JUDGE ORR RANCHETTES

CONSTRUCTION DOCUMENTS

PCD FILE NO:
SP-17-021

REV.	DESCRIPTION	DATE
1	ADDRESS AGENCY COMMENTS	10/23/18
2	ADDRESS AGENCY COMMENTS	12/18/18

JUDGE ORR RANCHETTES
STREET IMPROVEMENT PLAN & PROFILE

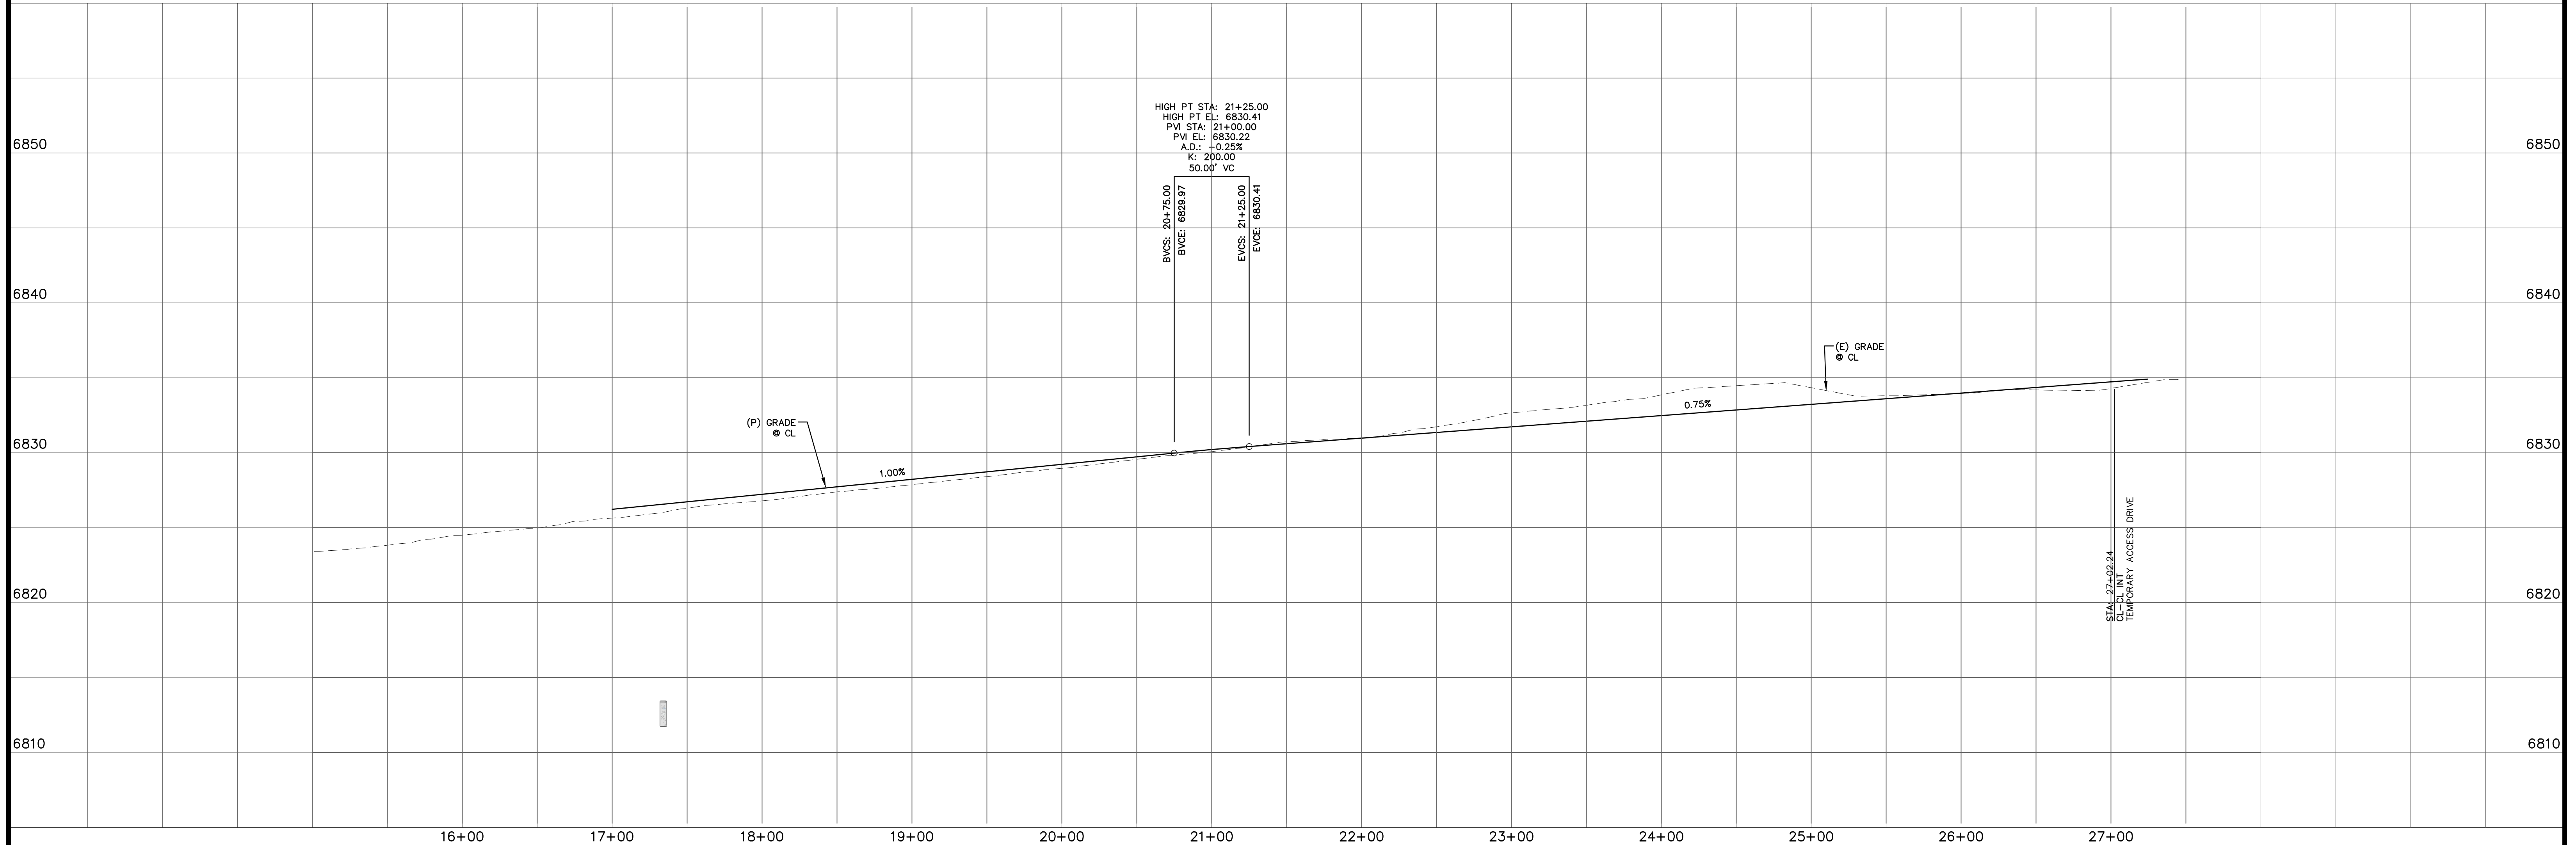
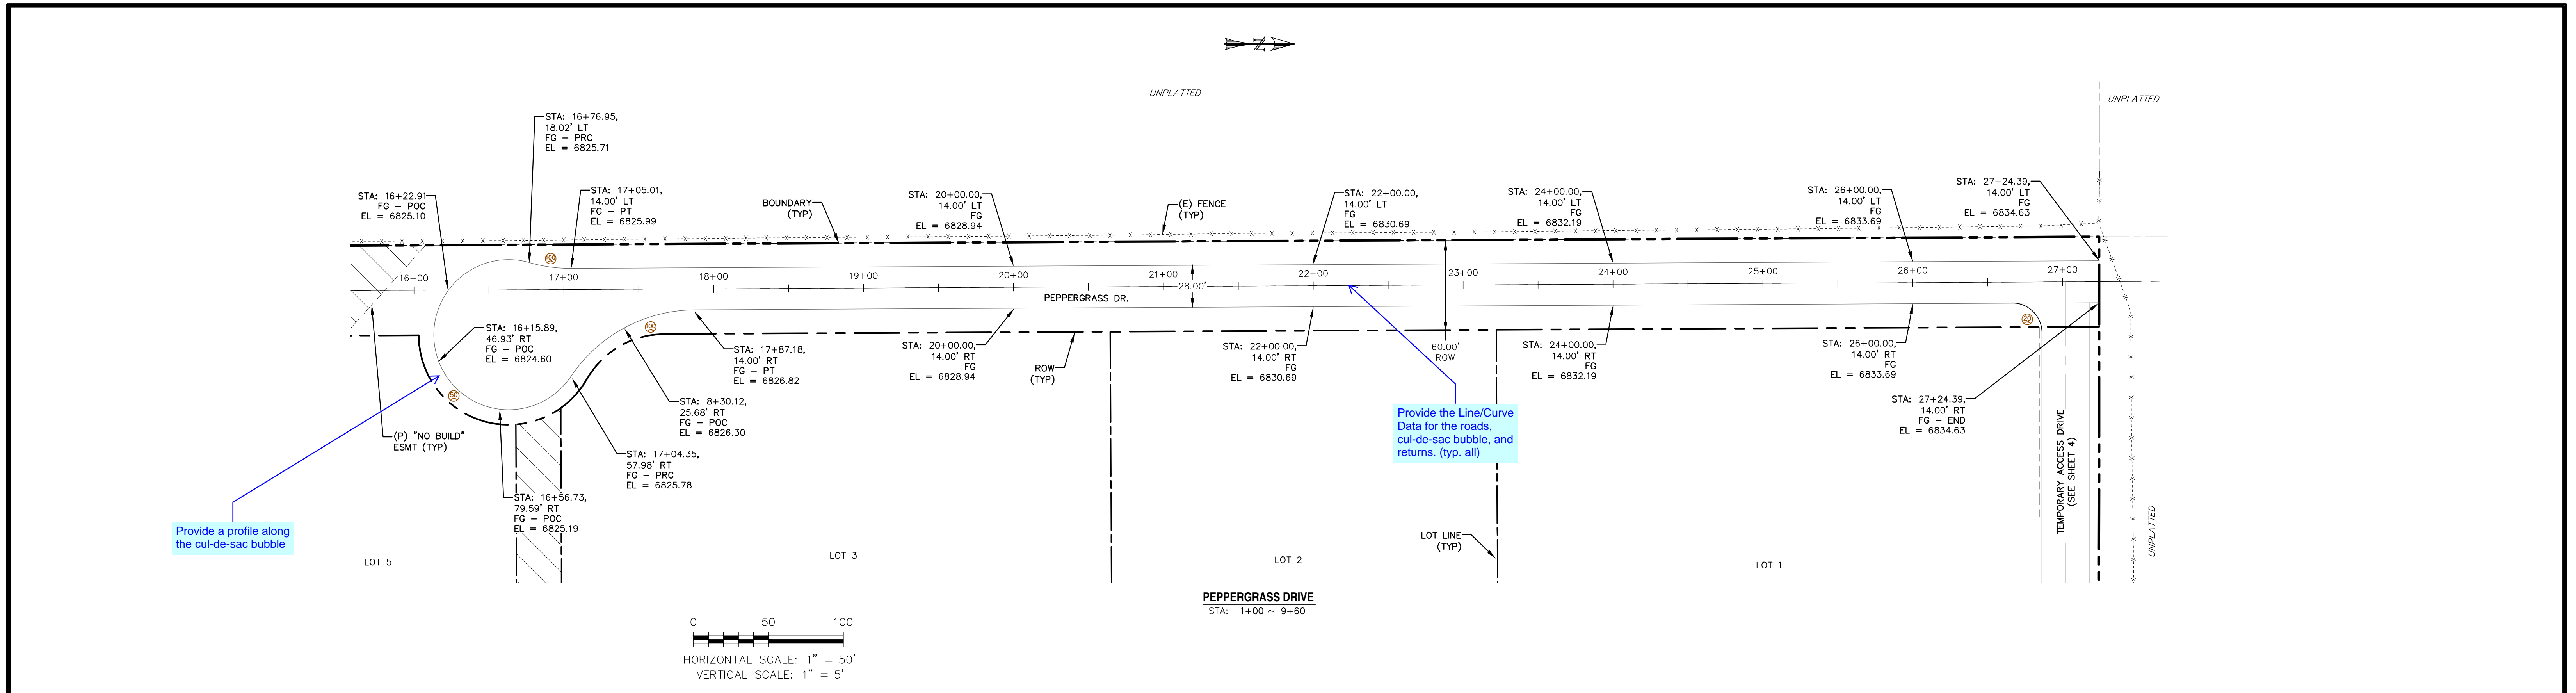
Riprap size does not match the outlet protection calculation in the drainage report.
